CITY OF ALBUQUERQUE

July 21, 2010

Re: Lot 9, Blk 4 Four Hills Village 14th Installment Grading and Drainage Plan
Engineer's Stamp date 7-13-10 (M23/D009)

**FOUR HILLS LOT SPLIT
FOR LOT 9, BLOCK 4
GRADING & DRAINAGE PLAN**

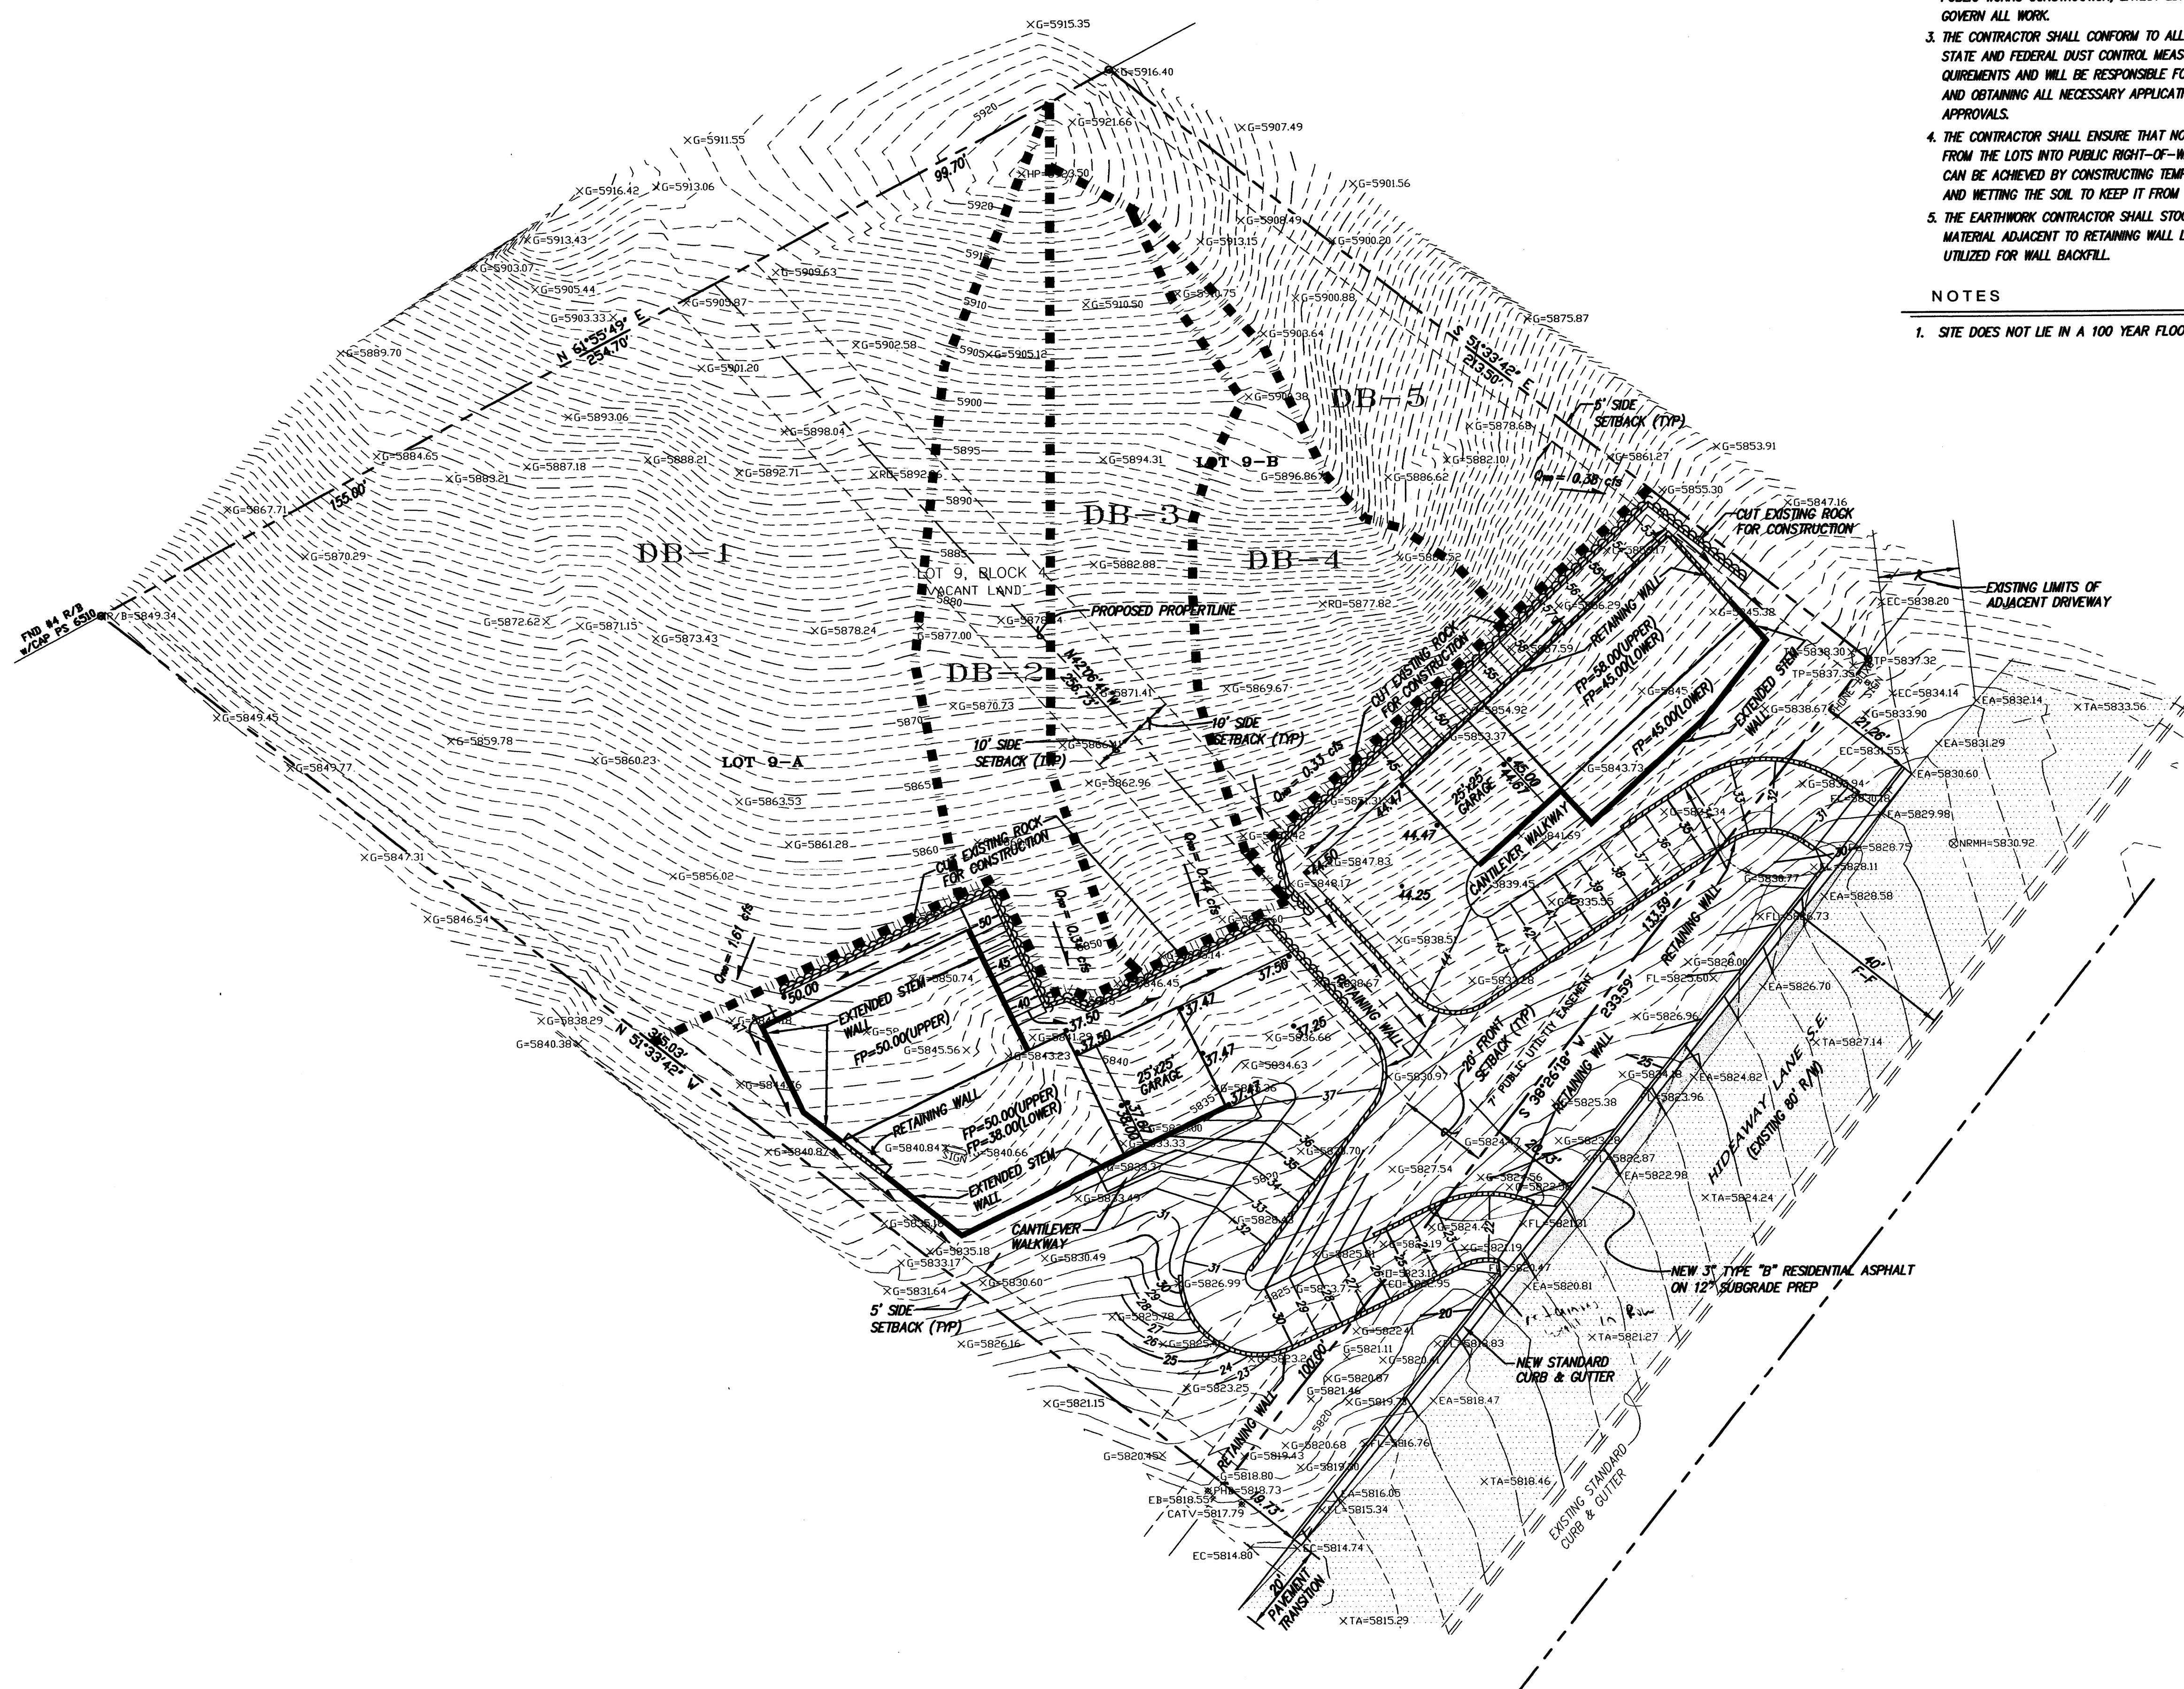
The plan is not approved for Grading Permit. A Grading and Drainage Plan for Building Permit will be required for each lot. Roof flows on the southern lot should drain down the driveway to Hideaway Lane. Erosion control will be required on both lots.

I told him the intent was to not have concentrated roof flows exit the property to the south.

So, if he can do something else as long as there are no concentrated roof flows leaving the property to the south.
